**Consultation Response from KC,
Lead Local Flood Authority**

2026/90435 Land Off, Cockley Hill Lane, Kirkheaton, Huddersfield, HD5 0HH

Discharge of details reserved by conditions 4 (Phase I Desk Study Report), 5 (Phase II Intrusive Site Investigation Report), 6 (Remediation Strategy), 13 (construction traffic), 15 (CEMP), 18 (drainage), 19 (CEMP: Biodiversity), 21 (landscaping) on previous permission 2021/92527 for erection of 29 dwellings, formation of access, public space, attenuation and associated infrastructure

Date Responded: 22nd March 2026

TITLE	
SURFACE WATER MANAGEMENT PLAN	
PROJECT	
COCKLEY HILL, KIRKHEATON	
CLIENT	
GLEESON HOMES	
DRAWING STATUS	
PRELIMINARY	
Scale	Date
1:500 @ A0	DEC 25
Drawn	Chk
IC	MI
Fig. No.	
2298/03/SK06	
Rev	7

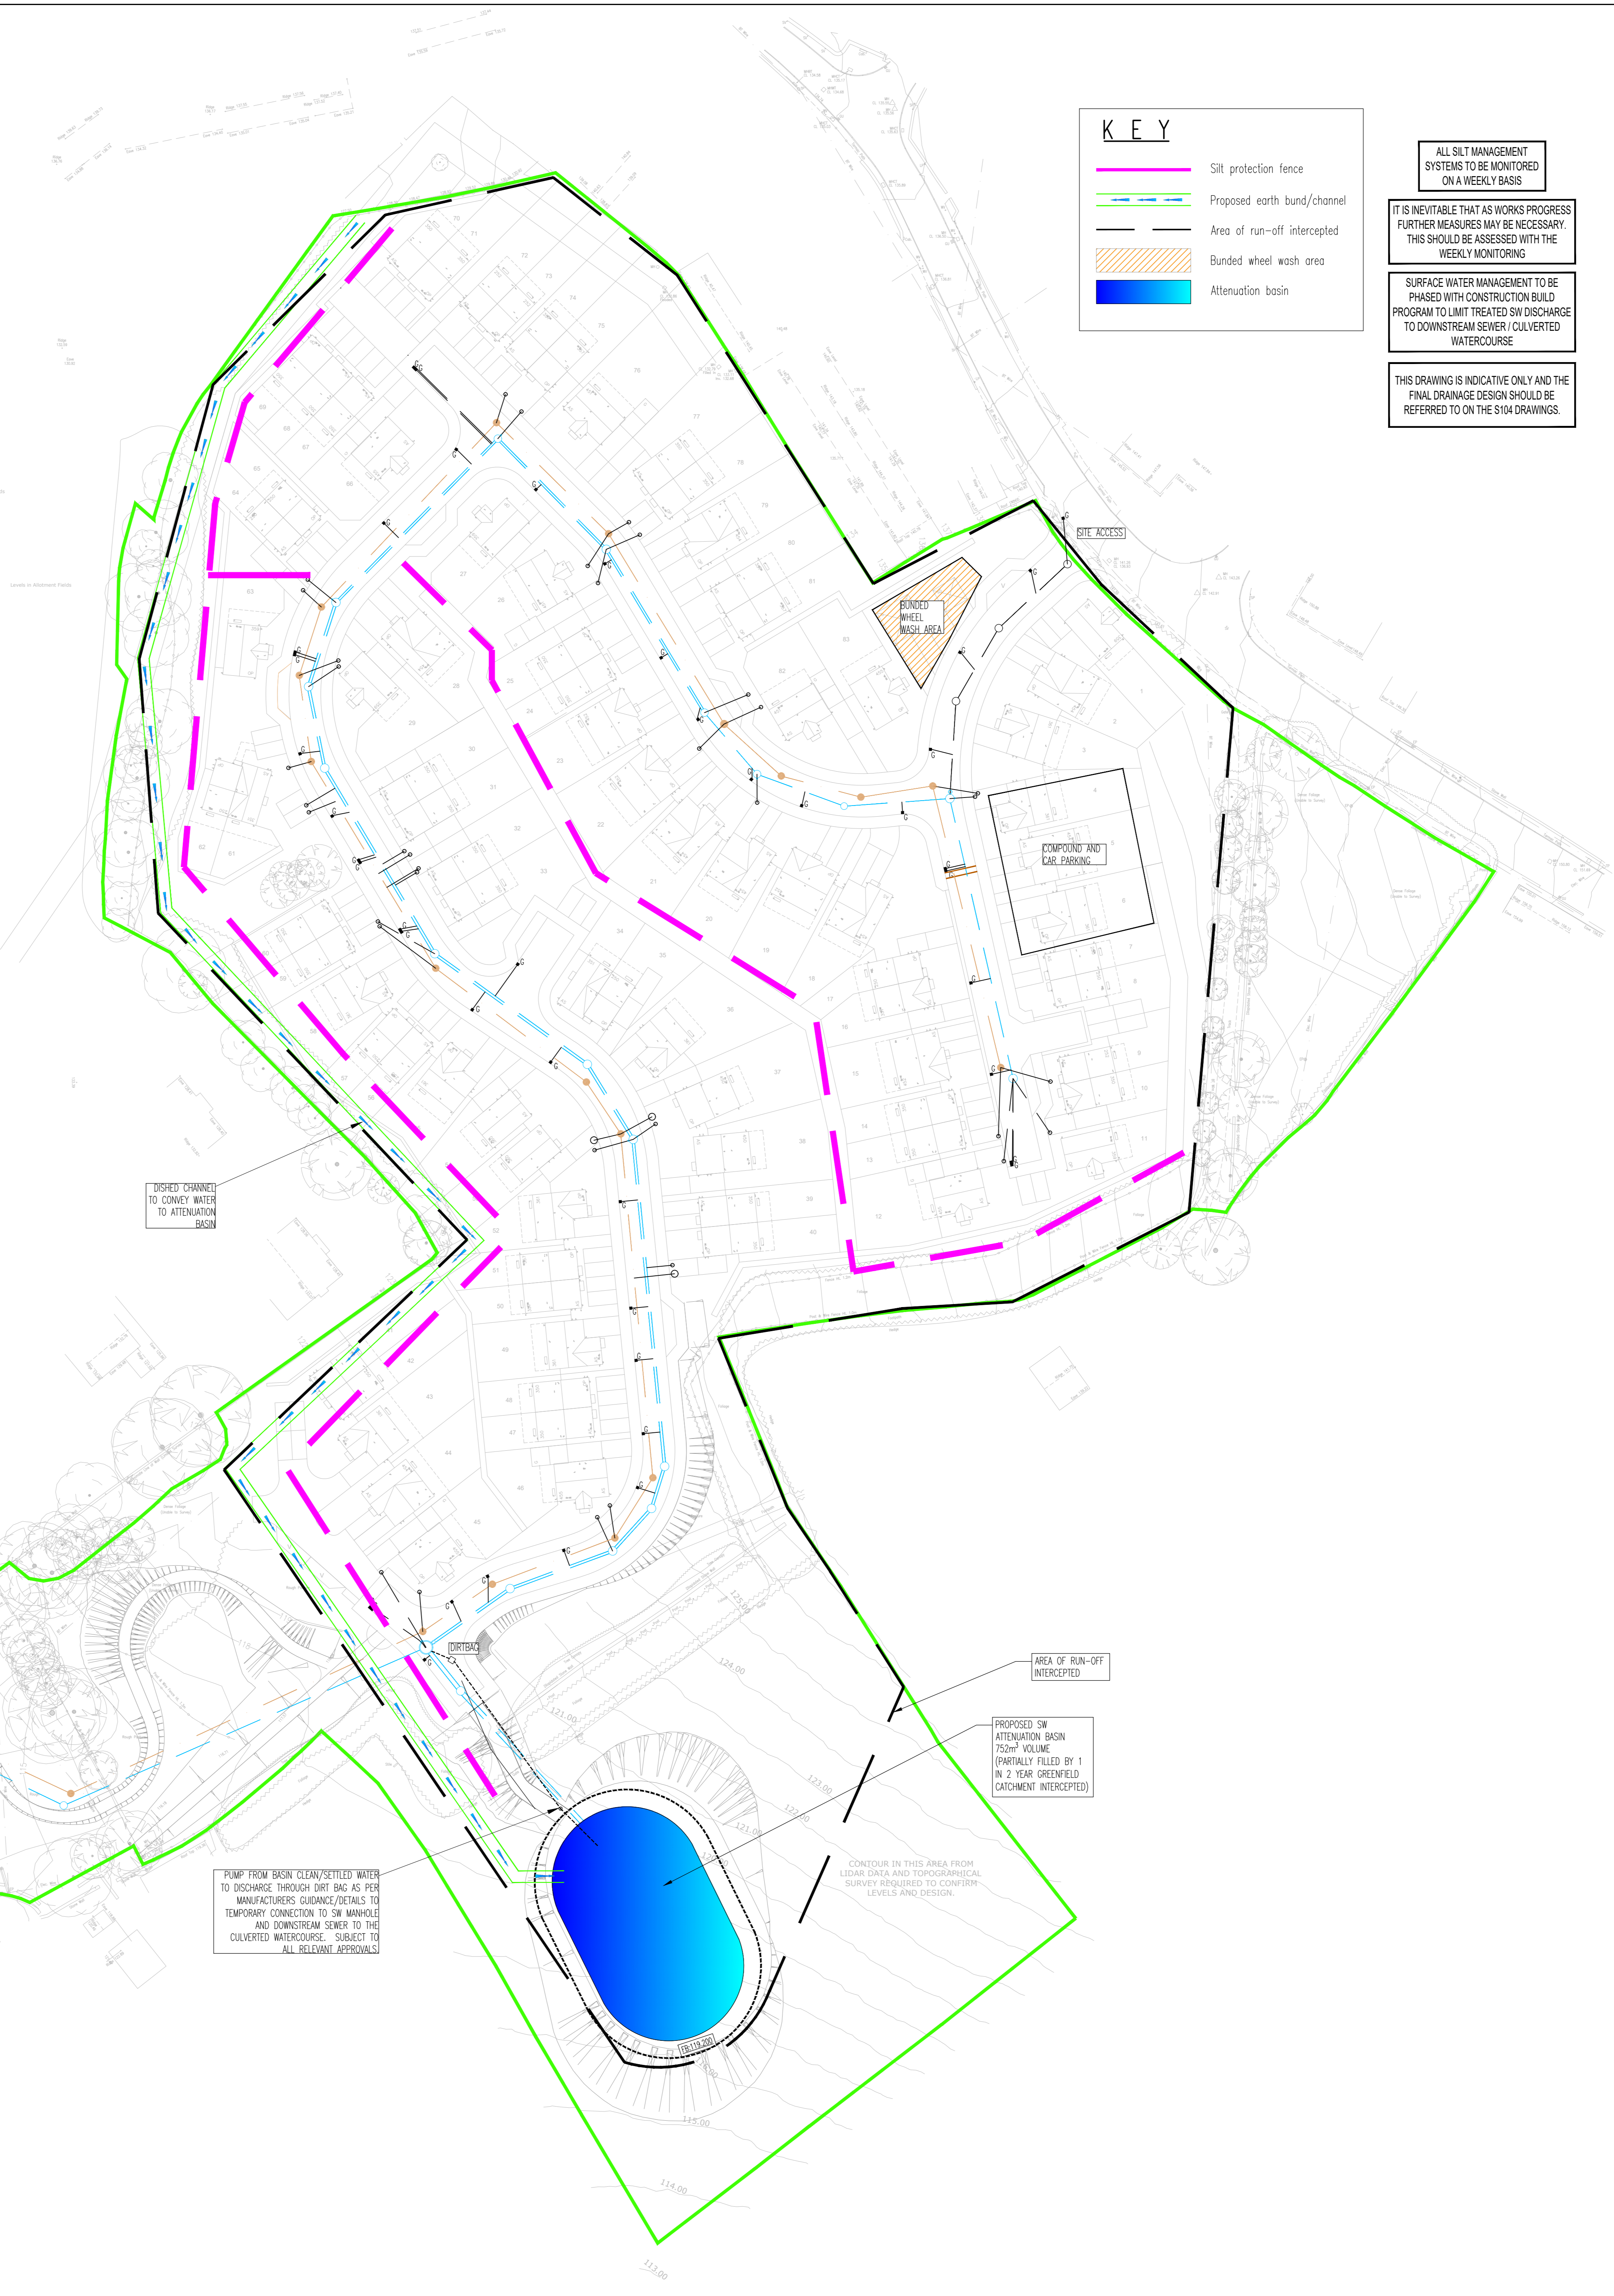
A temporary drainage plan and narrative have been submitted and accepted.

We recommend that this condition be discharged.
